WILLOWTREE PLANNING

31 March 2022

SSD-10470-Mod-1

**AMENDMENT OF MODIFICATION APPLICATION (SSD-10470-MOD-1)
WOOLWORTHS WAREHOUSE AND DISTRIBUTION CENTRE AUBURN
PROPERTY AT 11 & 13 PERCY STREET, AUBURN**

Drawing Title:
Ground Floor Plan

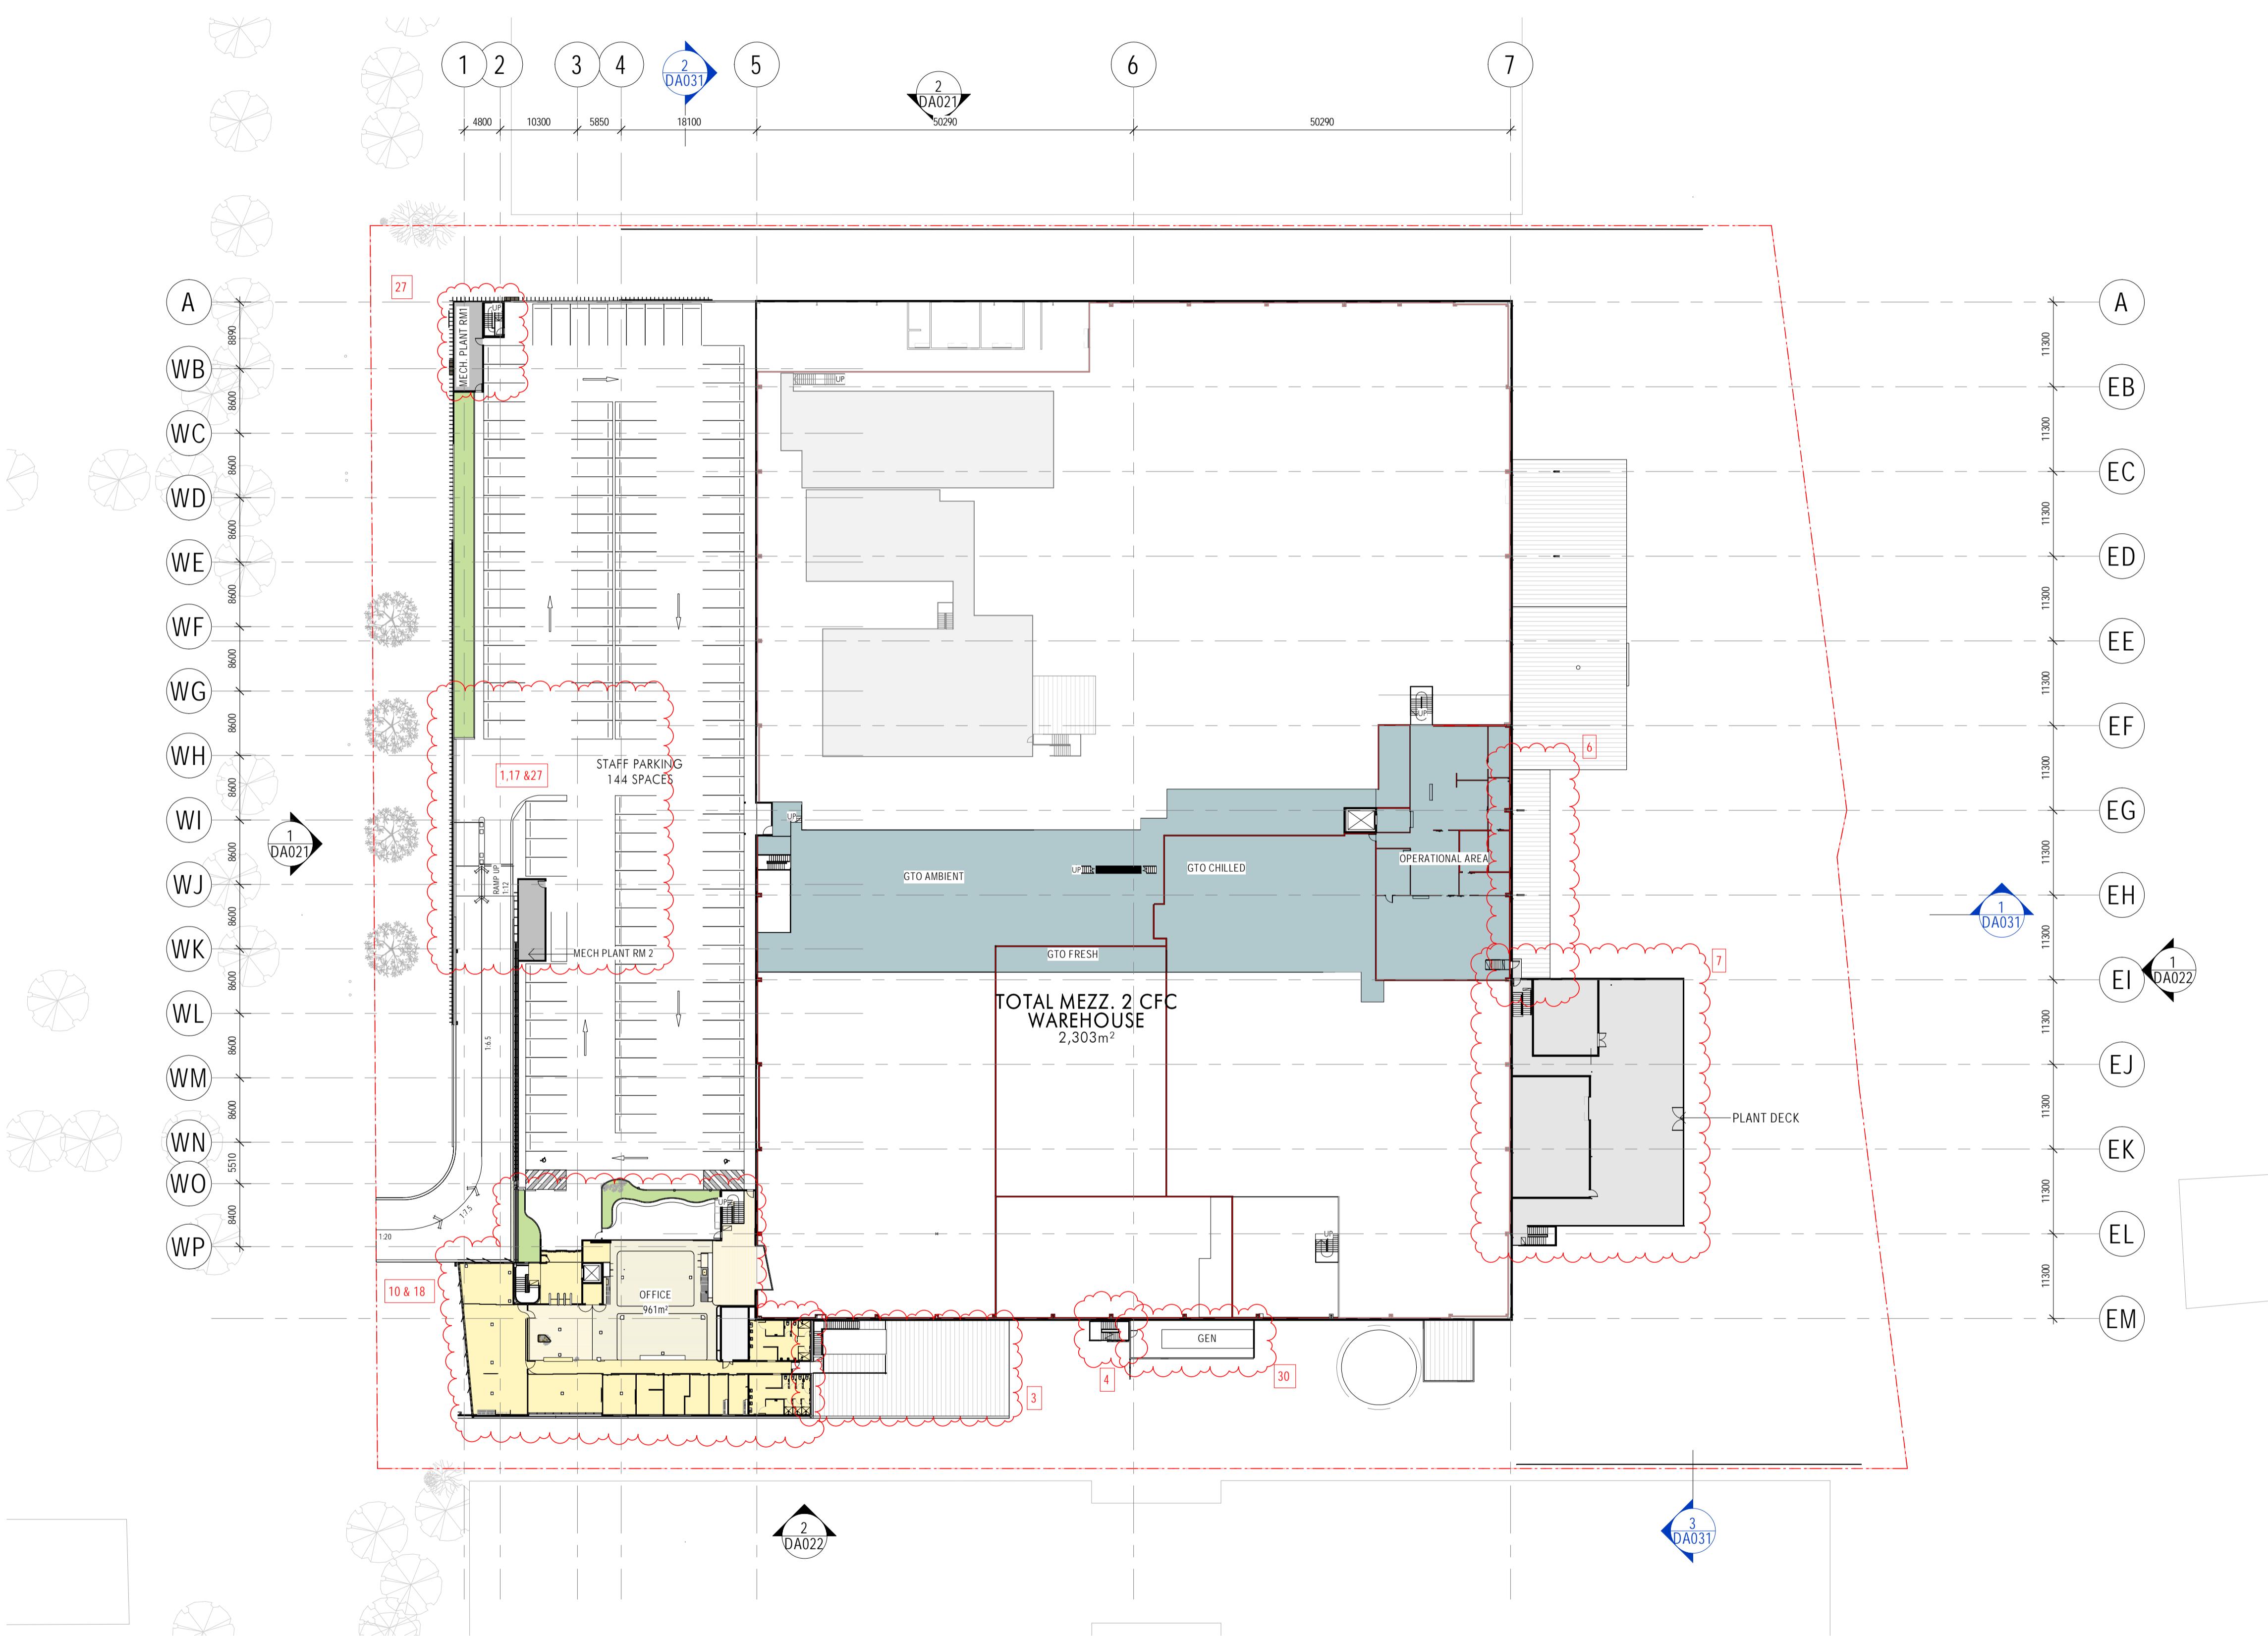
The proposal seeks to slightly modify the layout of the plant room further to what has been proposed as part of the original Modification Application and RTS. The footprint of this plant area is consistent with the current proposal, however the layout within is altered, as described below.

The purpose of the proposed plan amendments (HV compound expansion, expansion of switch room and relocation of solar inverter room to L1) is to allow for the future provision of electric delivery vehicles rather than diesel.

1. Change solar room to storage room at ground level, adjacent to switch room;
2. New solar room relocated to upper level of plant area (above storage room);
3. Addition of future substation; and
4. Reconfiguration of the backup generator location and loss of one (1) van space to accommodate the abovementioned amendments.
